Traffic Related Comments on Luddenham Advanced Resource Recovery Centre SSDA

Land use zoning

Subject to the permissibility of development being addressed, the following traffic related comments and conditions are to be taken into consideration:

**ROADWORKS PLAN**  
SCALE 1:250

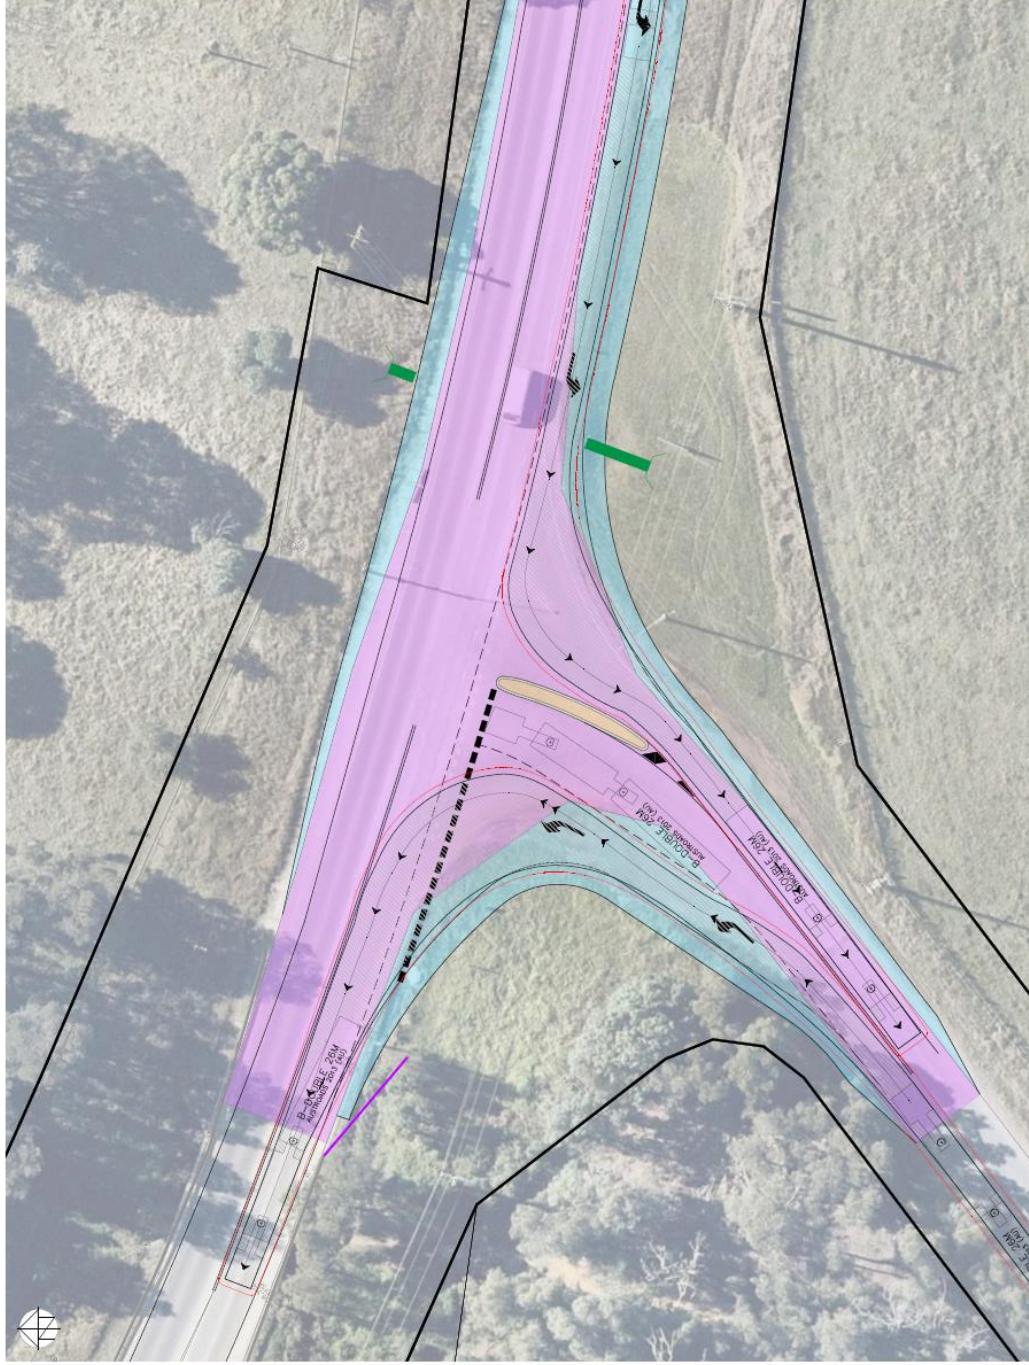
In this regard, as discussed at the recent meeting, an interim intersection treatment is required before Elizabeth Drive is widened and for an ultimate intersection treatment and revised haulage route to be agreed to.

The applicant is now proposing interim intersection treatment which involves the following:

- A 120 m deceleration left-hand turn lane into Adams Road.
- Road widening of the existing Elizabeth Drive/Adams Road intersection to accommodate B-double swept paths.
- Provision of a short-left turn lane on Adams Road into Elizabeth Drive.
- Banning right turn movements from Elizabeth Drive west into Adams Road.

This intersection configuration is supported. In-principle approval is required from TfNSW for the proposed interim intersection upgrade. A Traffic Management Plan is required to be submitted to TfNSW and Council for banning right turn movements from Elizabeth Drive West into Adams Road.

The developer is required to execute a Work Authorisation Deed (WAD) agreement with TfNSW for the proposed interim intersection works.
